**Subject:** RE: 2025/90413 - Land adjacent, 40, Manchester Road

This is a holding objection until details have been sorted.

Proposed rear/south east facing elevation (1:100).

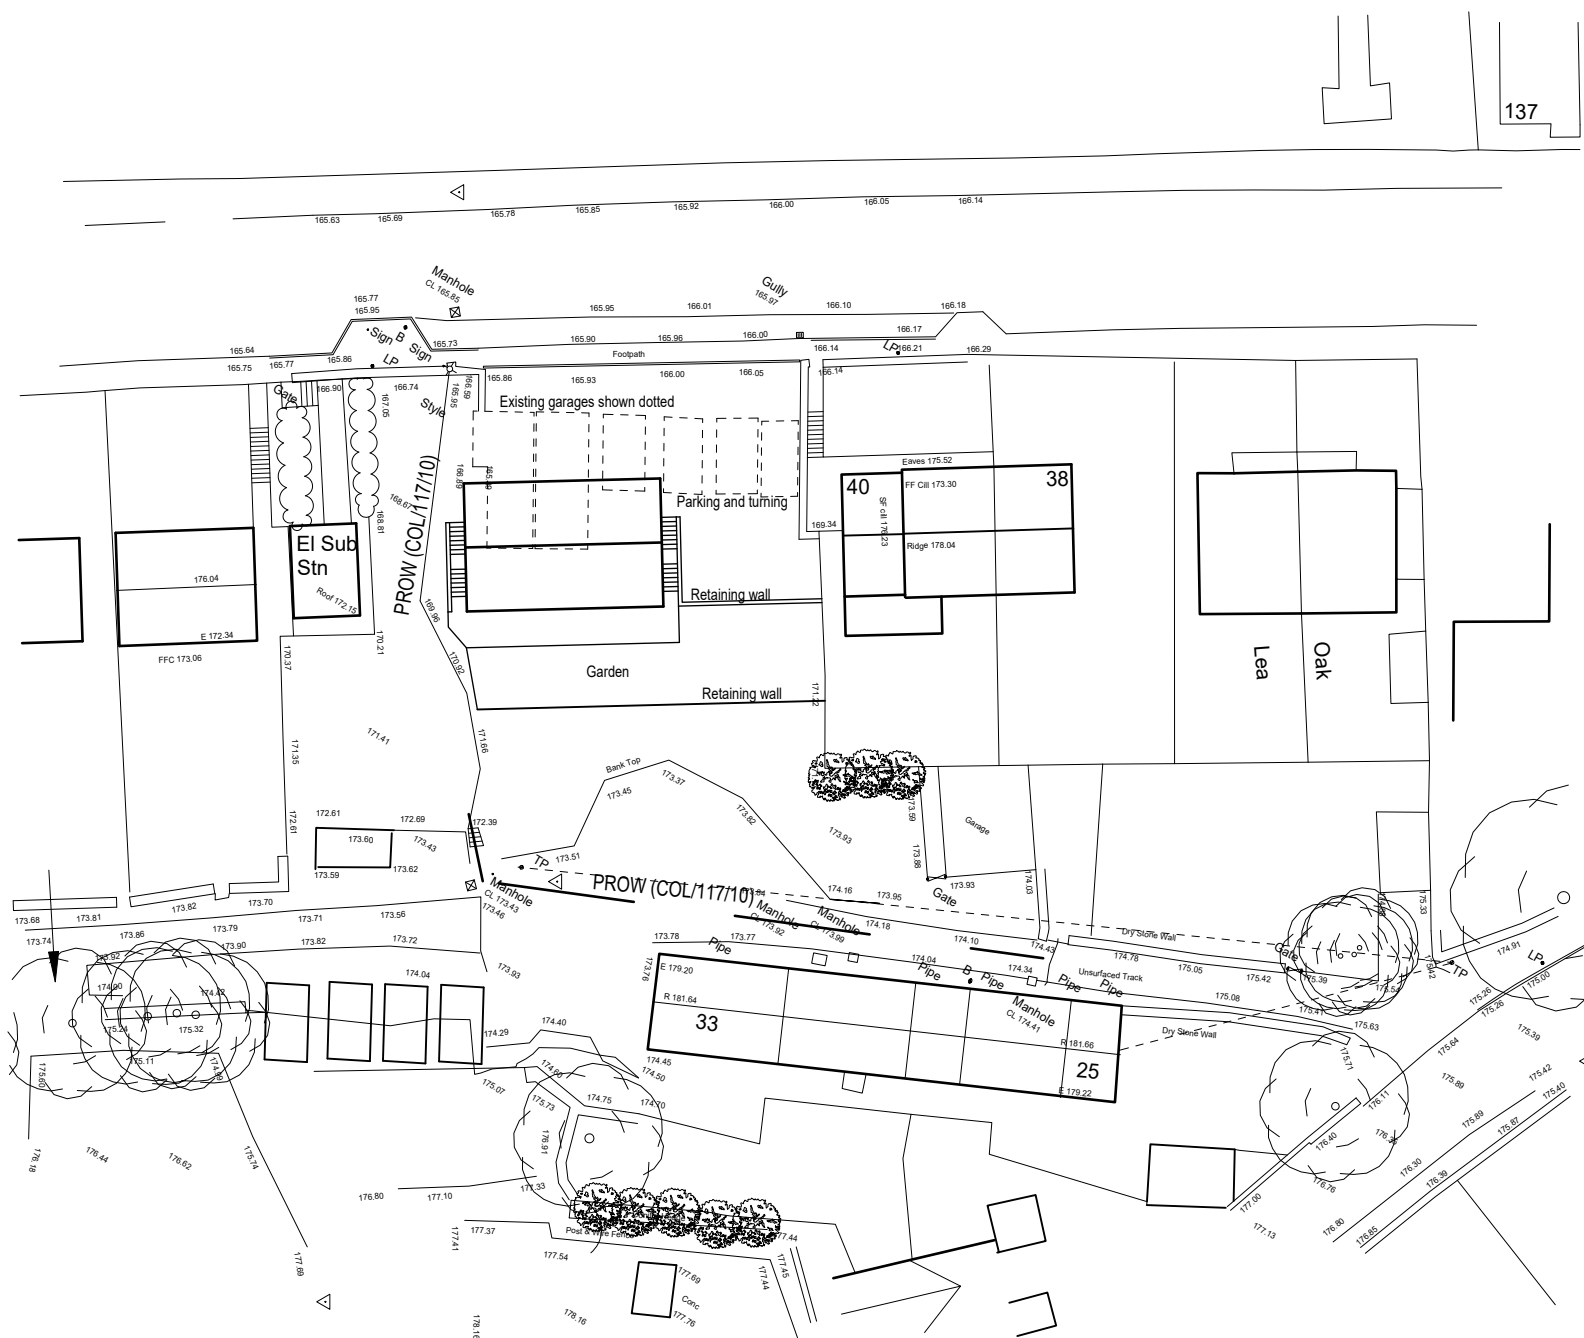
Also what is the retaining wall where the steps are, at the moment, this is a shallow grass bank, but the external steps appear to go to first floor level and the patio?

how are the steps going to fit in with the footpath, are they just adjacent to each other and what is to stop the public using the house steps?

Proposed block plan (1:500).

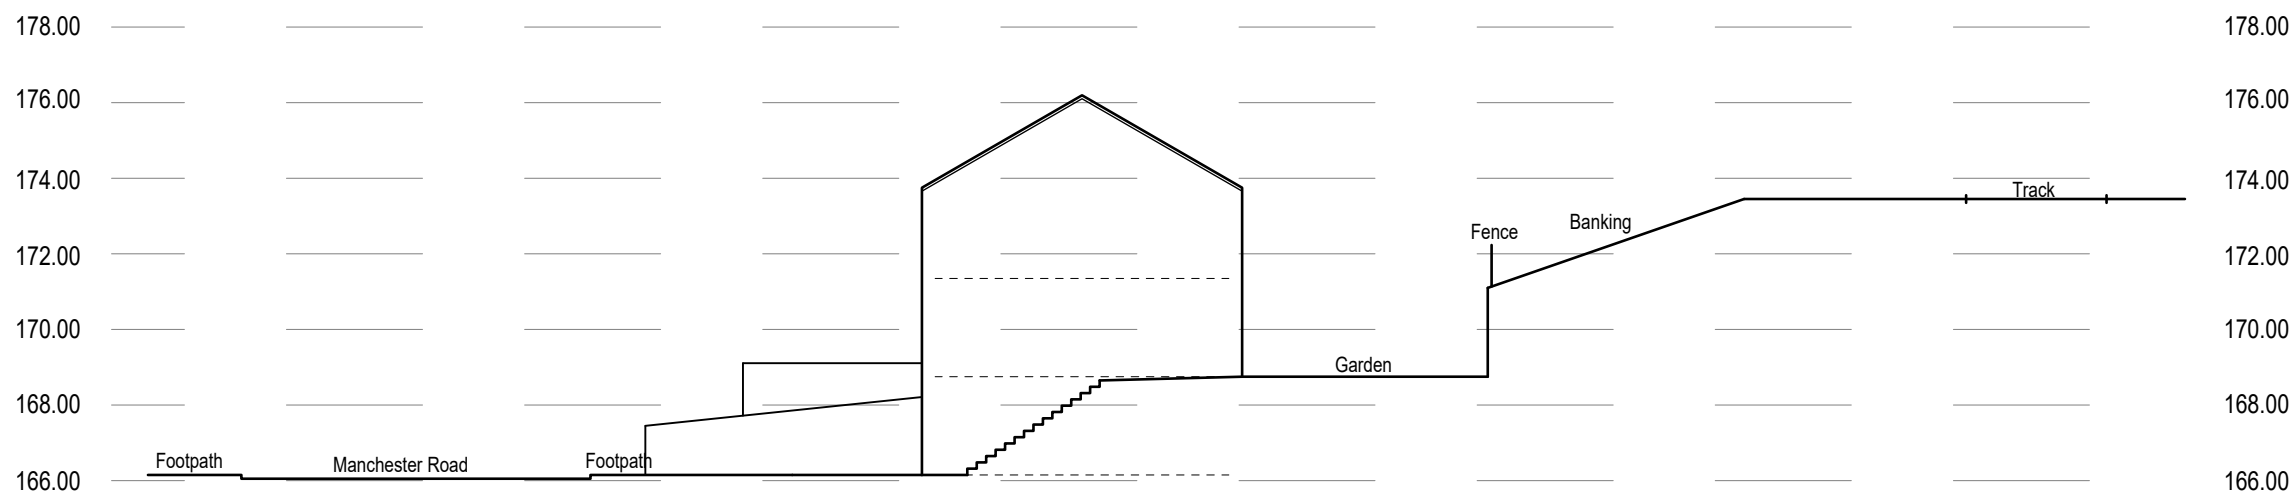
The alignment of the footpath is worked out from the ordnance survey map shown below, which is recorded as a straight line. Questions I have are :-

I think that the application proposes to move the footpath slightly to put more curve in it. Is this due to the steps?

The submissions do not appear to match between the 2 plans. This one below, has a right angled bend in, whilst the one you included only has a curve. Also the plan below does not appear to meet the track at the same place.

Submissions indicate that the path will not be affected, but we are unsure that the path can be retained especially whilst the development is taking place
